**The Member-Secretary**

**Letter No. C3(S)/1374/2016****Dated : 27.03.2016**

**Sub:** CMDA – Area Plans Unit – MSB (South) Division - Planning Permission Application for the construction of Basement floor + Stilt floor + 11 Floors - Residential Multi-Storeyed Building with 22 dwelling units at Door No. 39, South Canal Bank Road, Raja Annamalaipuram, Mylapore, Chennai – 28, comprised in R.S.No. 4310/4, Block No. 96 and R.S.No.4569/16, Block No.100 of Mylapore village, Chennai – DC advice Sent – Reg.

ALL FLOOR PLAN SHEET.NO-01/03

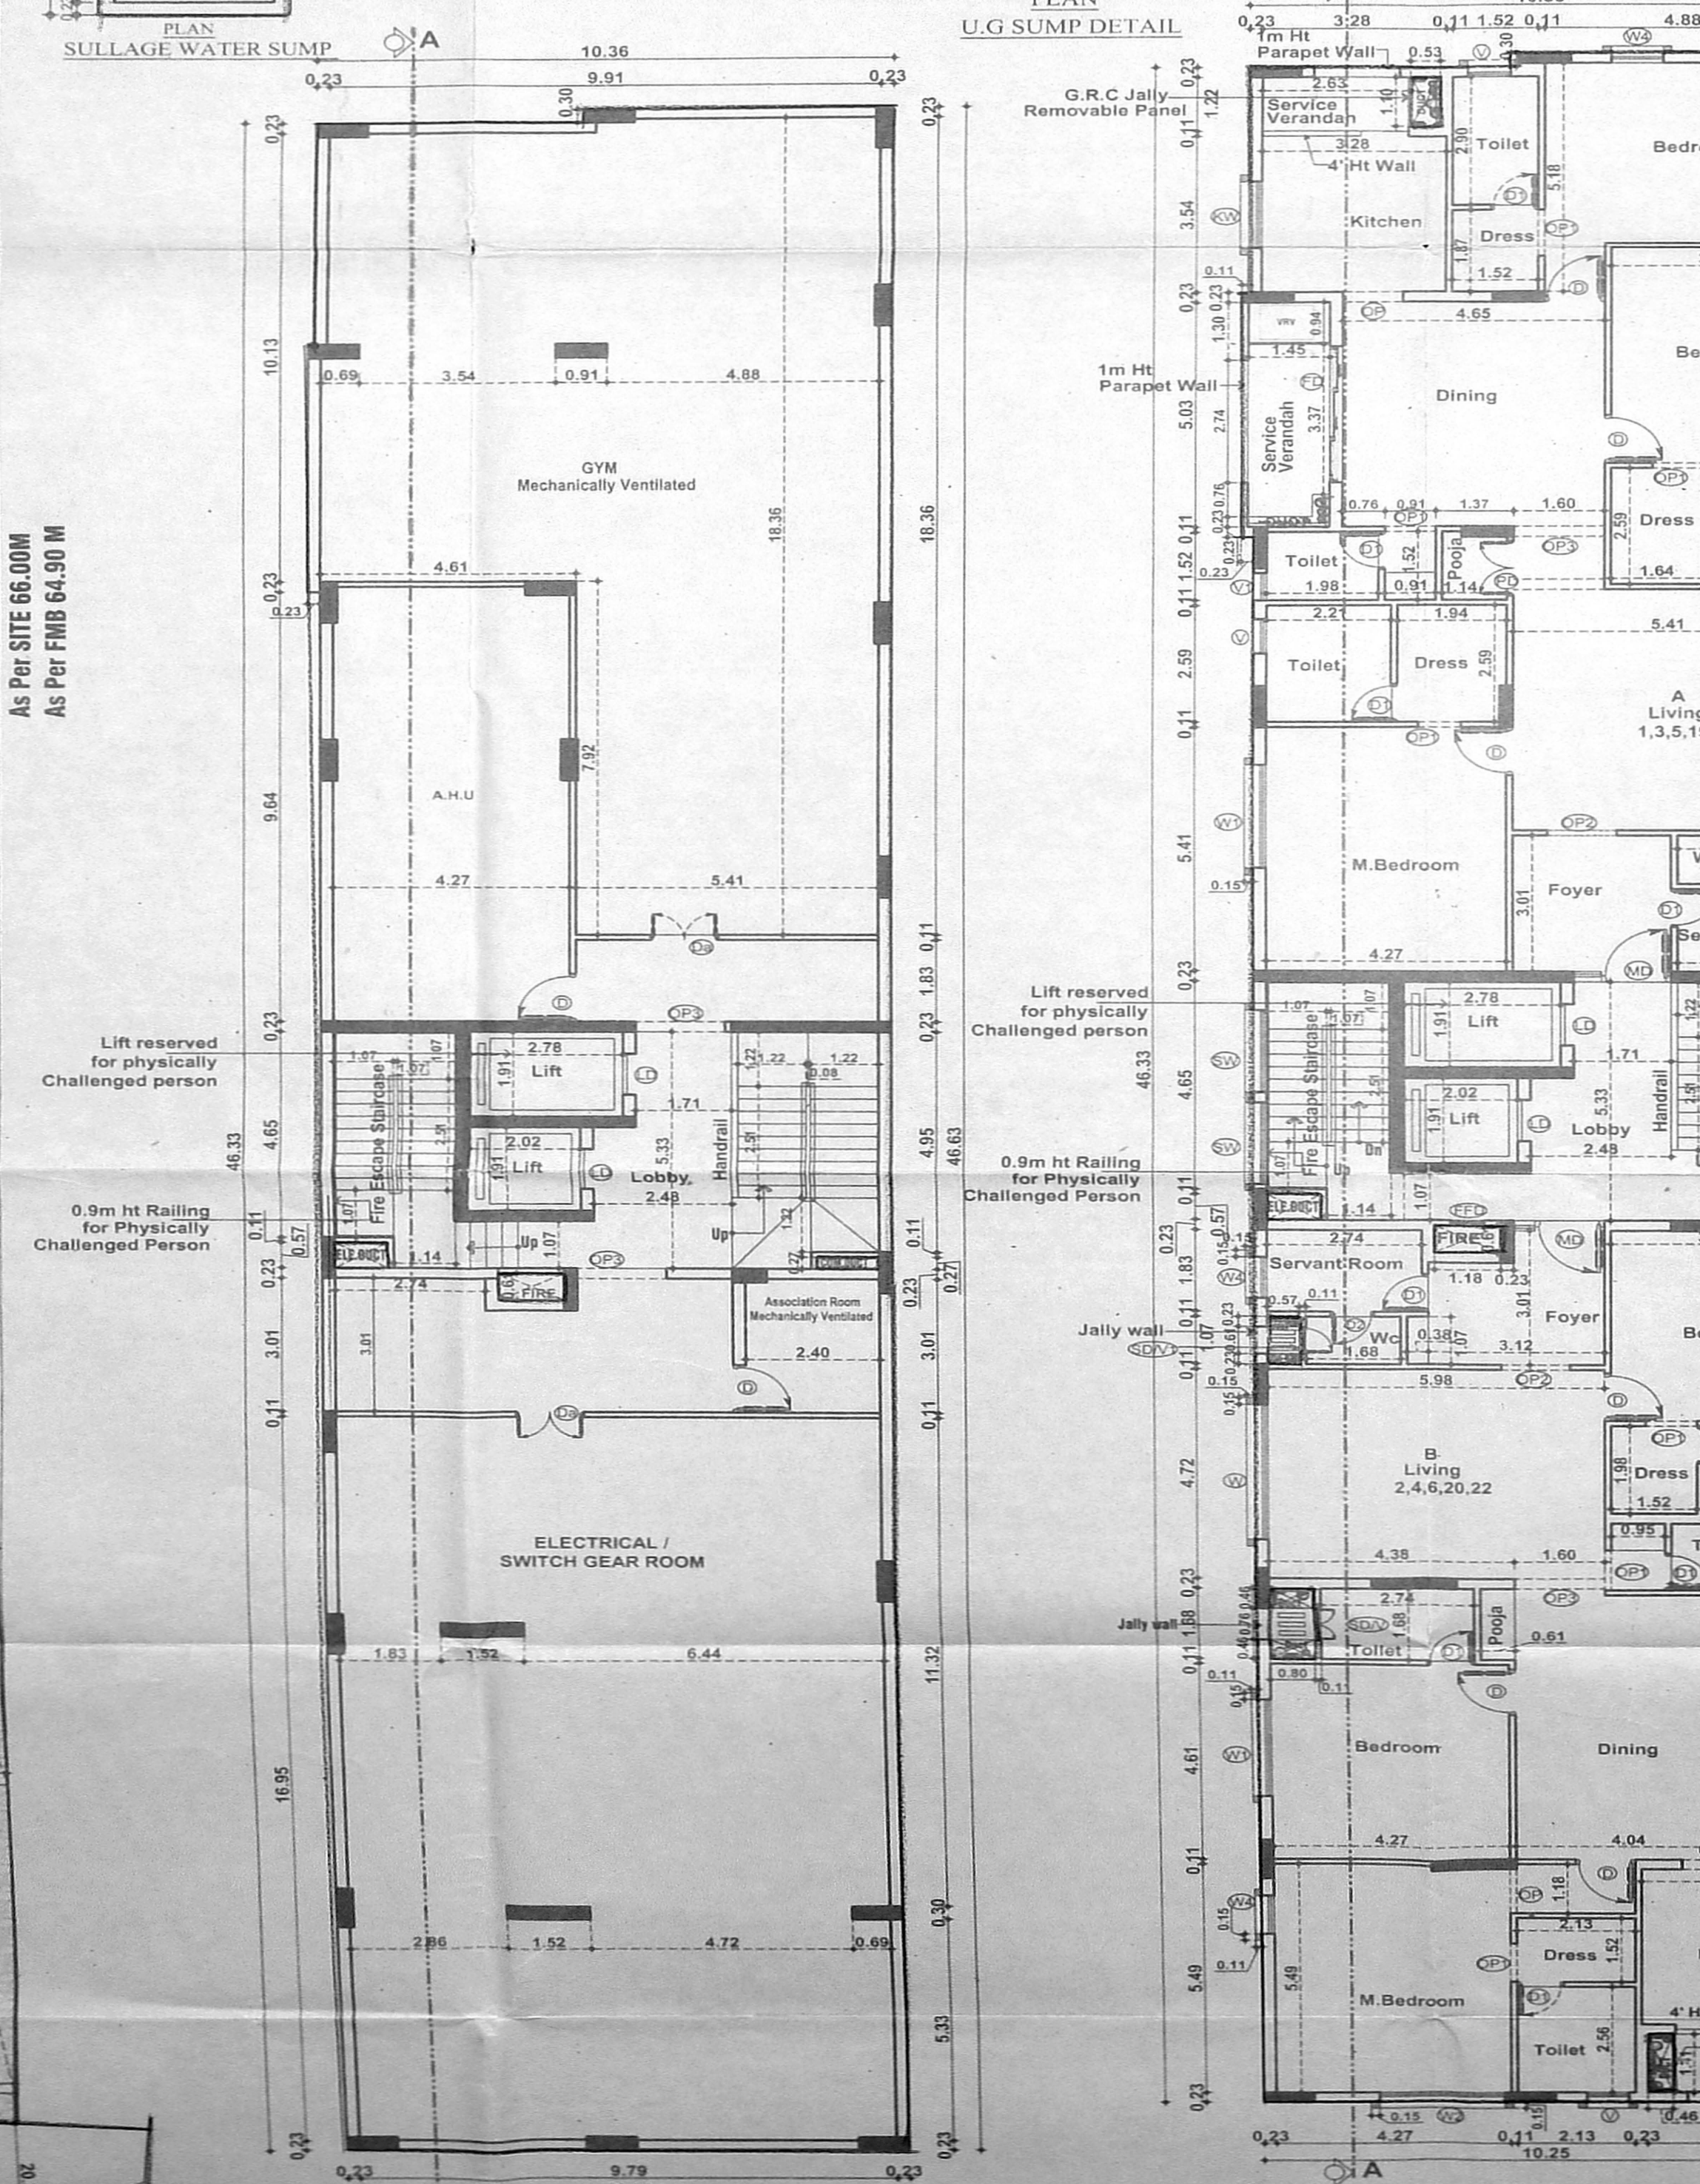
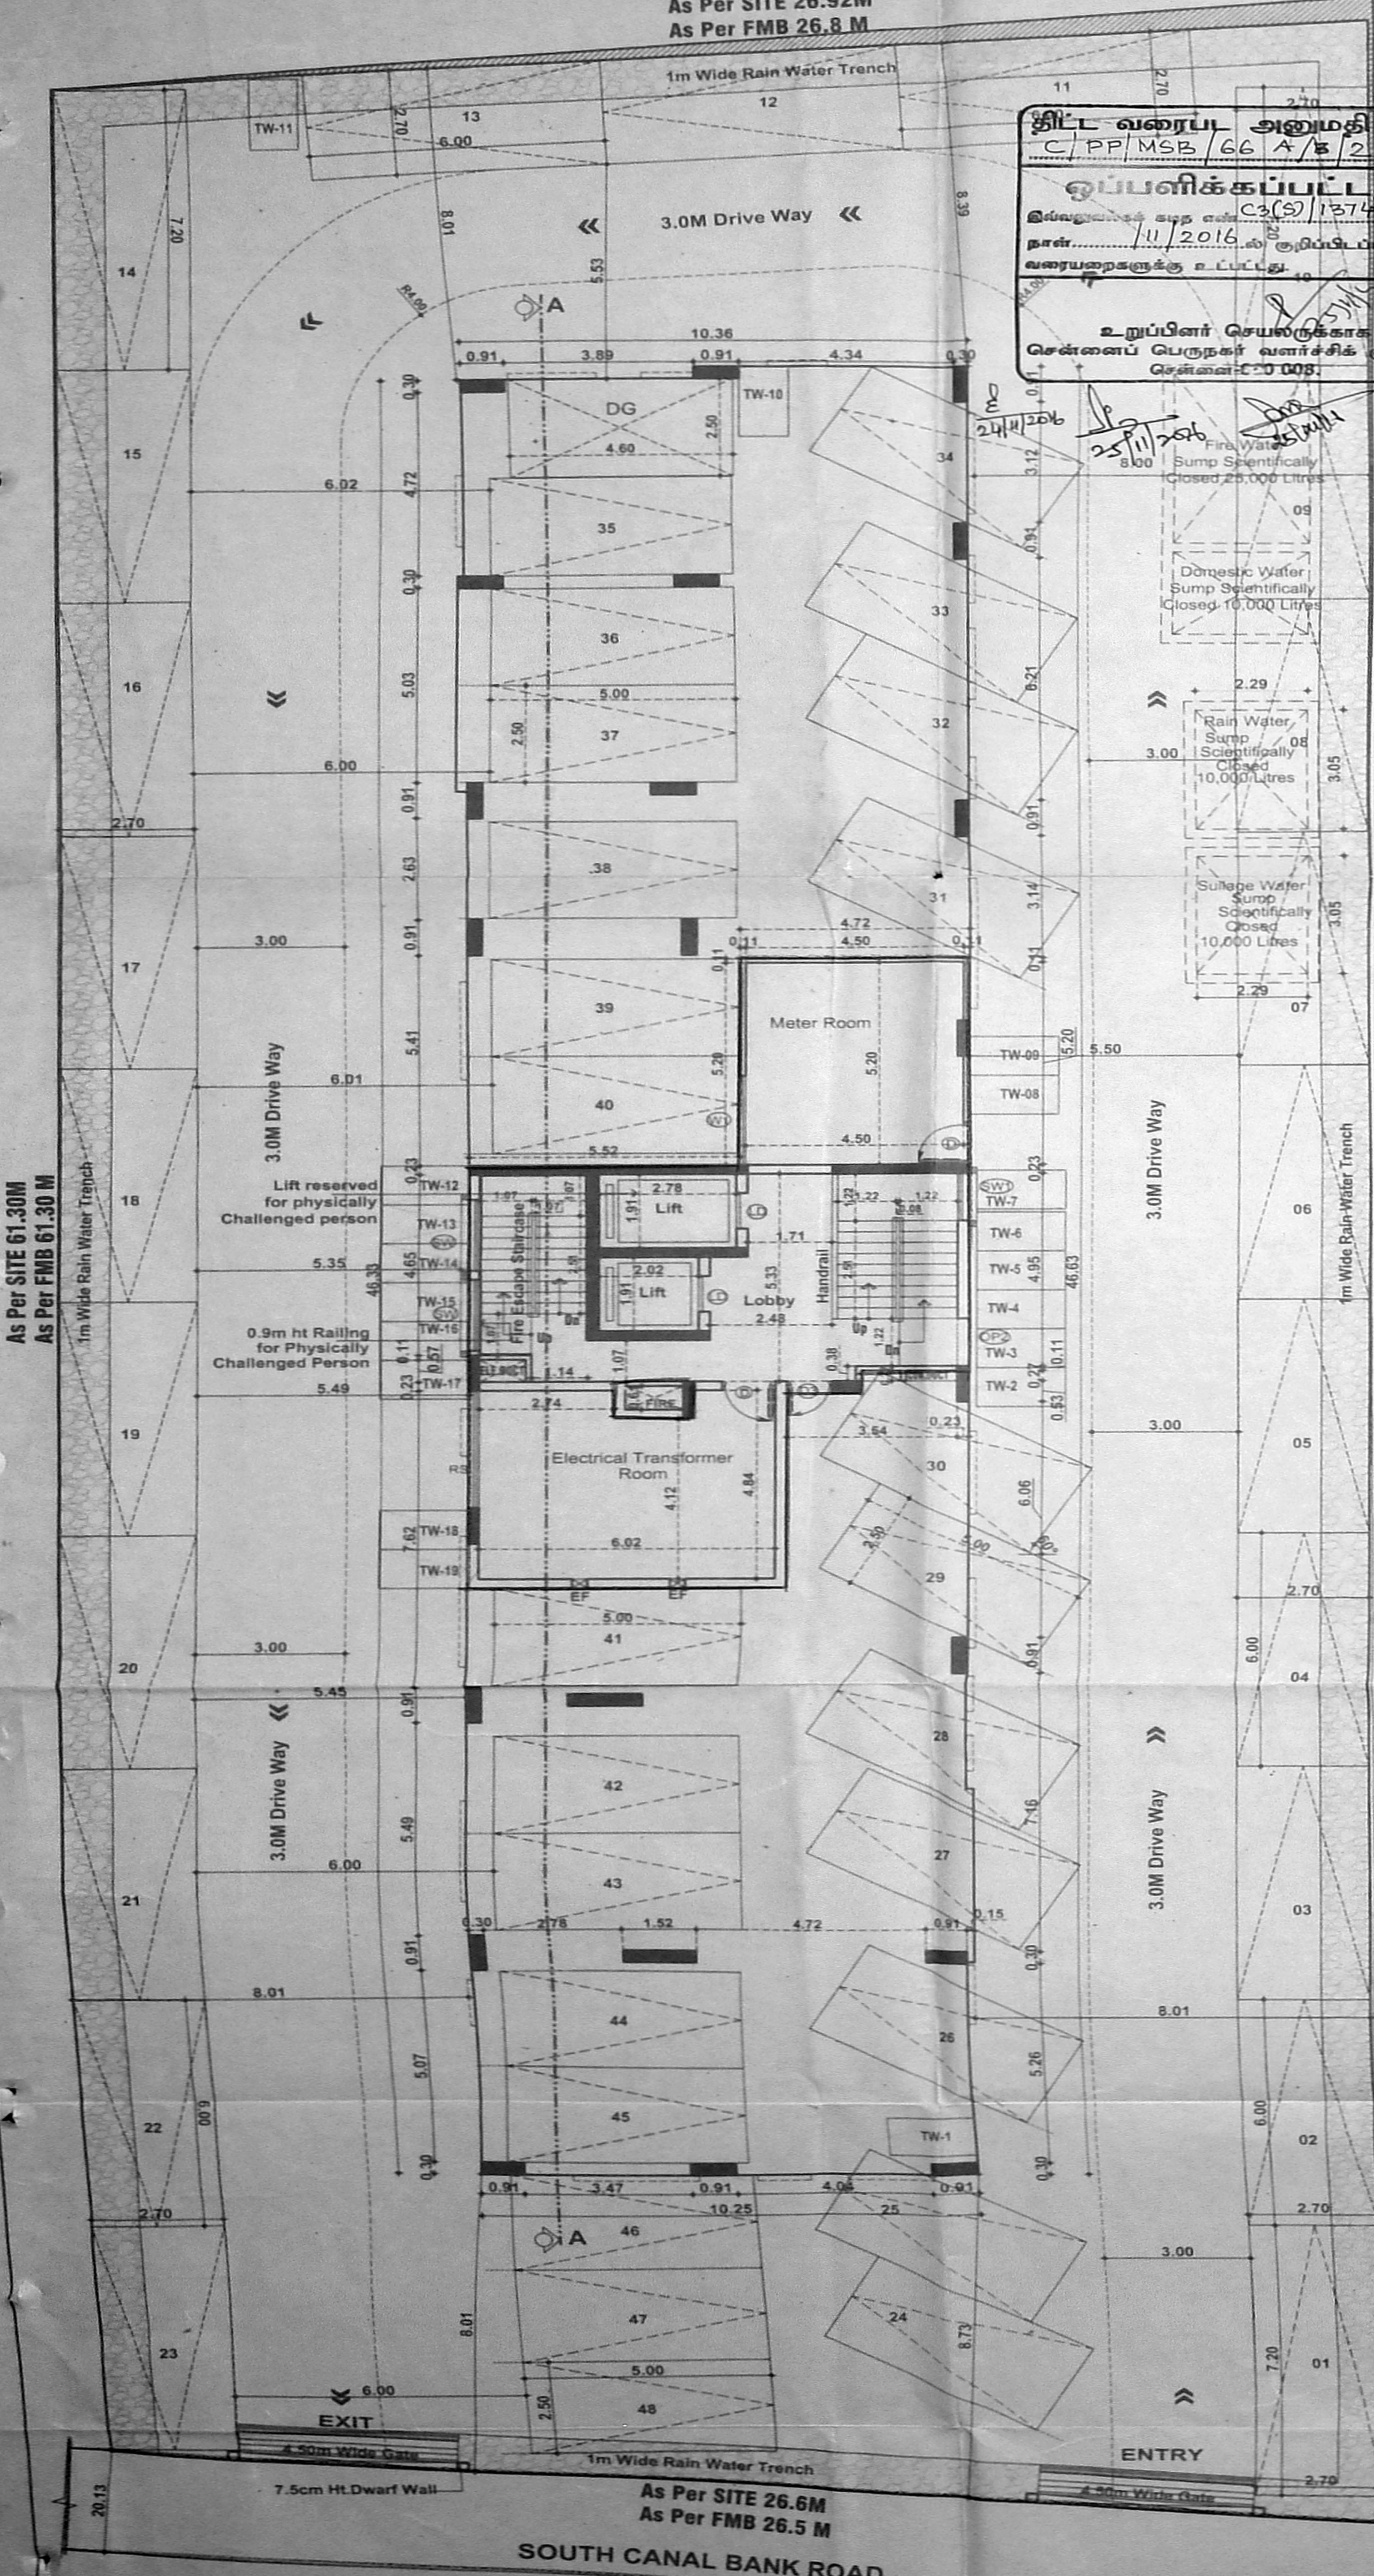
- (i) DG located at setback space is not permissible and hence the same is to be re-located either in Stilt floor or in Basement floor.
- (ii) All set in balconies and Utility are to be re-named as Service verandah provided with 1.0m height parapet wall/handrail and plumbing point.
- (iii) Electrical room is to be re-named as Electrical meter room.
- (iv) UG Sump for Rain water collection & Re-cycled Sullage water are to be provided.
- (v) The height of parapet is to be restricted to 1.0m at Terrace floor.
- (vi) Clear height of Basement floor and Stilt floor are to be mentioned in Cross section plan.
- (vii) As on site dimension and road width are to be shown tallying with inspection plan.
- (viii) Area statement to be corrected as per actual calculation.
- (ix) Sheet numbers are to shown as 1/3, 2/3 and 3/3.

(x) Transformer yard & security cabin are to be located after leaving min. required setback of 7.20m

(xi) Gym intended for human habitation proposed in Basement floor without ventilation is not permissible.
